CITY OF PORTLAND
 FIRE PREVENTION BUREAU
 380 Congress Street, Portland, Maine 04101
 fireprevention@portlandmaine.gov
 (207) 874-8400

NOTICE OF VIOLATION AND ORDER TO CORRECT

October 25, 2017

Responsible Party 1: AMERICAN NATIONAL RED CROSS 524 FOREST AVE PORTLAND, ME 04101		
Location 2401 CONGRESS ST	CBL 239A A004001	Inspection Date 9/18/2017
Inspector Jonathan Hendricks	Inspection Type FP Routine Inspection Commerci	Status Failed

LIFE SAFETY PLAN
 $1/8" = 1'-0"$

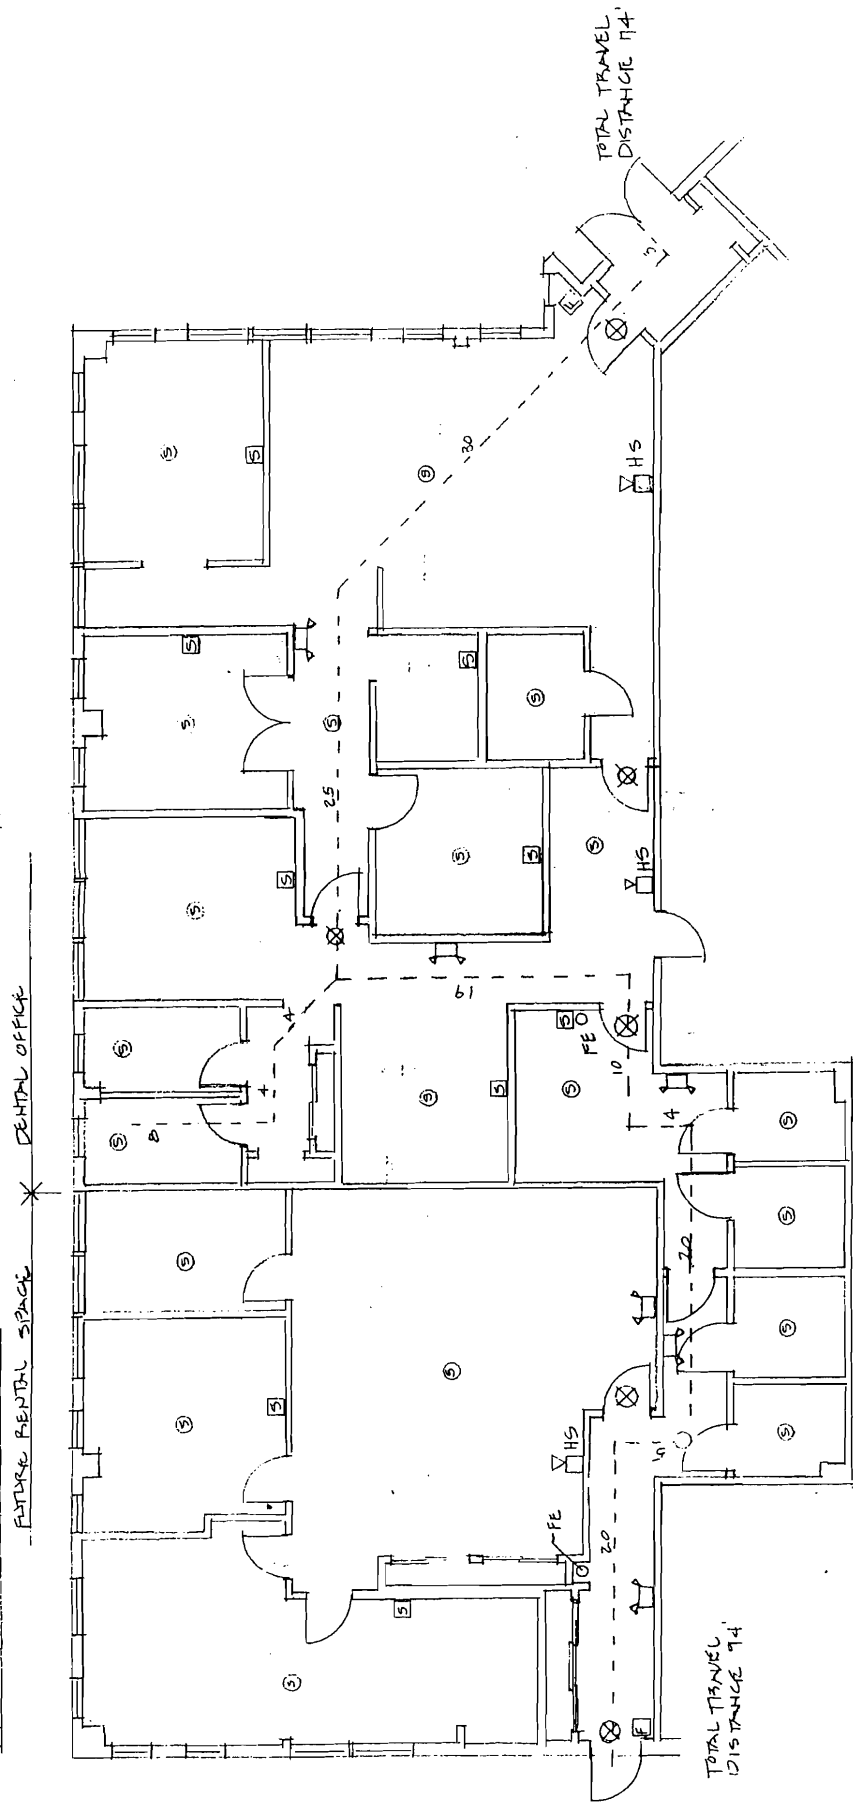
Violation	Proposed Date of Completion
NFPA 101- 7.10.1.1 EXITS CLEARLY VISIBLE OR CONSPICUOUSLY INDICATED; Where Required: Means of egress shall be marked in accordance with section 7.10 where required in Chapters 11 through 43. Exits lights were not illuminated	___/___/___
1-4.5.8 MAINTENANCE, INSPECTION, AND TESTING; WHENEVER OR WHEREVER ANY DEVICE, EQUIPMENT, SYSTEM, CONDITION, ARRANGEMENT, LEVEL OF PROTECTION, FIRE-RESISTIVE CONSTRUCTION, OR ANY OTHER FEATURE IS REQUIRED FOR COMPLIANCE WITH THE PROVISIONS OF THIS CODE, SUCH DEVICE, EQUIPMENT, SYSTEM, CONDITION, ARRANGEMENT, LEVEL OF PROTECTION, FIRE-RESISTIVE CONSTRUCTION, OR OTHER FEATURE SHALL THEREAFTER BE CONTINUOUSLY MAINTAINED. Emergency lights not operational	___/___/___
FINAL DATE OF COMPLETED VIOLATION(S)	___/___/___
FIRE PREVENTION BUREAU RE-INSPECTION OF COMPLETED VIOLATION(S)	___/___/___
